**Consultation Response from KC,
Trees**

2025/93438 Arena Young Peoples Centre, Moorlands Road, Dewsbury, WF13 2LF

Erection of 10-unit (class C2) special needs care home, day centre (class E(f)), administration and training building (class E(g)(i))

Date Responded: 05/03/2026

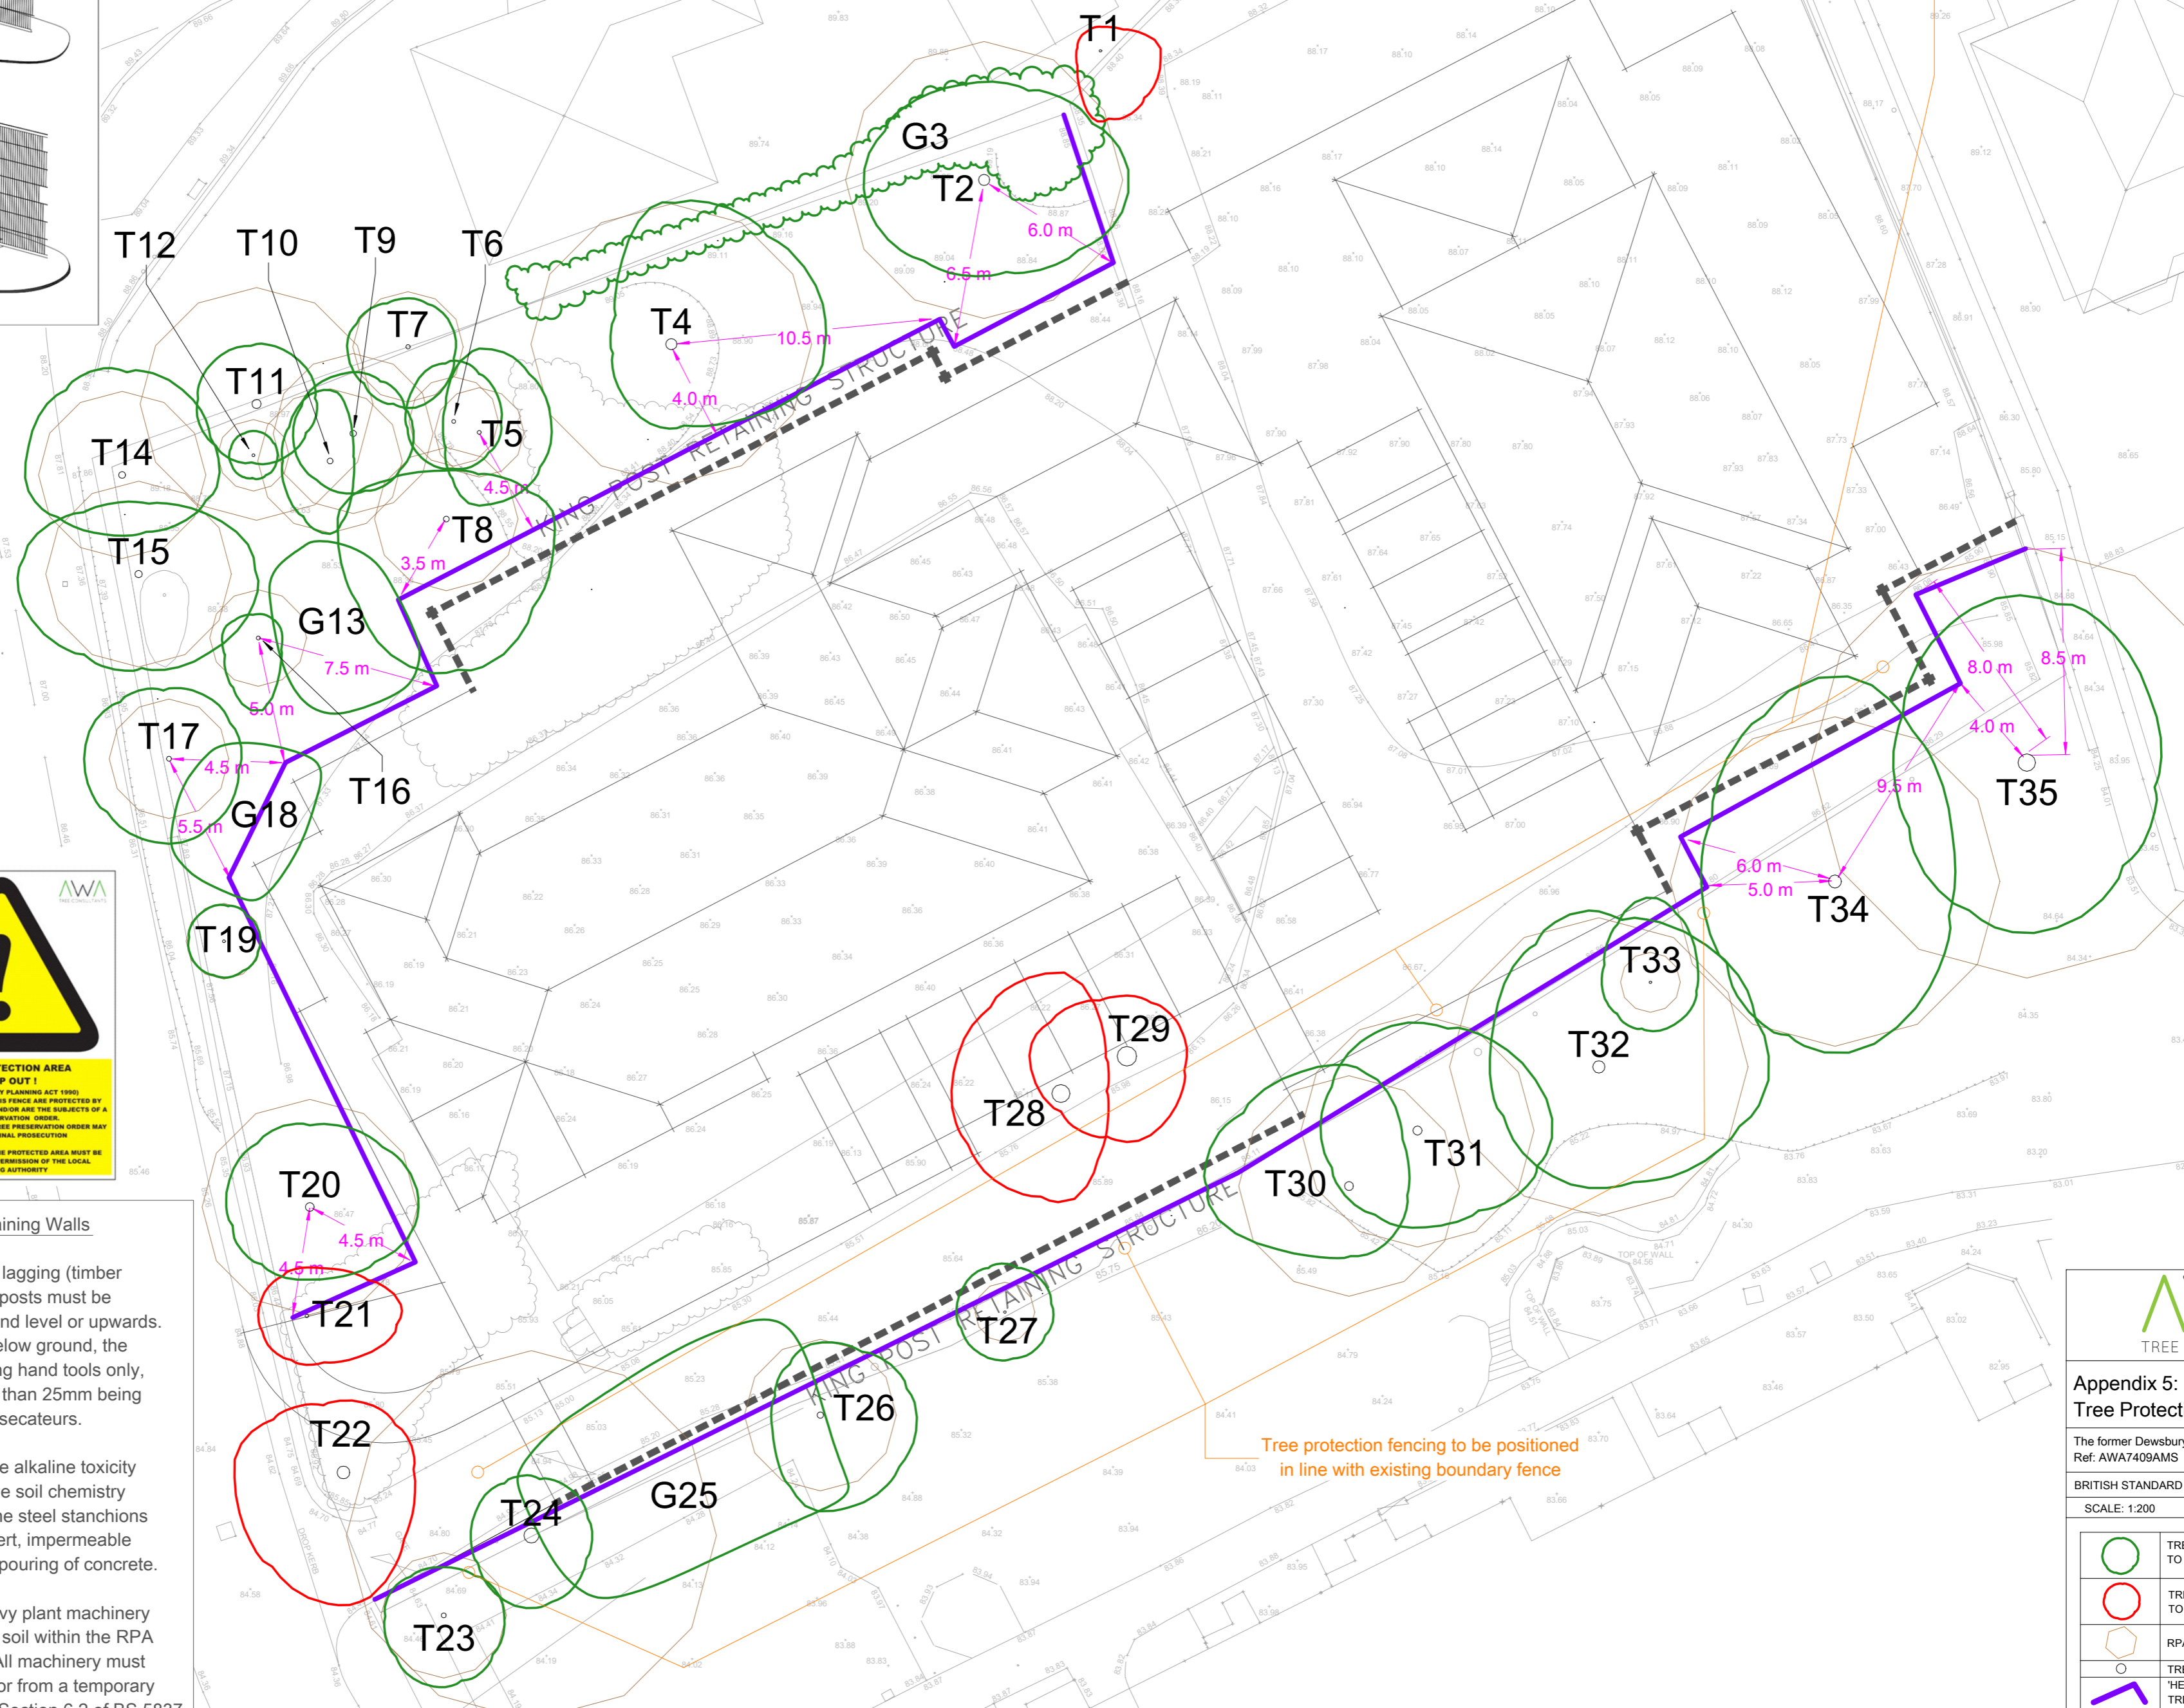
The drawing provided does not conform to BS5737:2012 and cannot be accepted. Additionally, the tree works outlined within the submitted tree survey plan does not conform with the landscaping plan. To move forward, we require the full arboricultural reports and separate plans as outlined in my previous comments. These must be produced by a suitably qualified arboriculturist.

Whilst the degree of incursion into RPAs varies, I note that the proposed retaining wall would sever a significant portion of the RPA on the south side of the tree T7. This may cause the tree to become destabilised and threaten the building in the future and should be avoided.
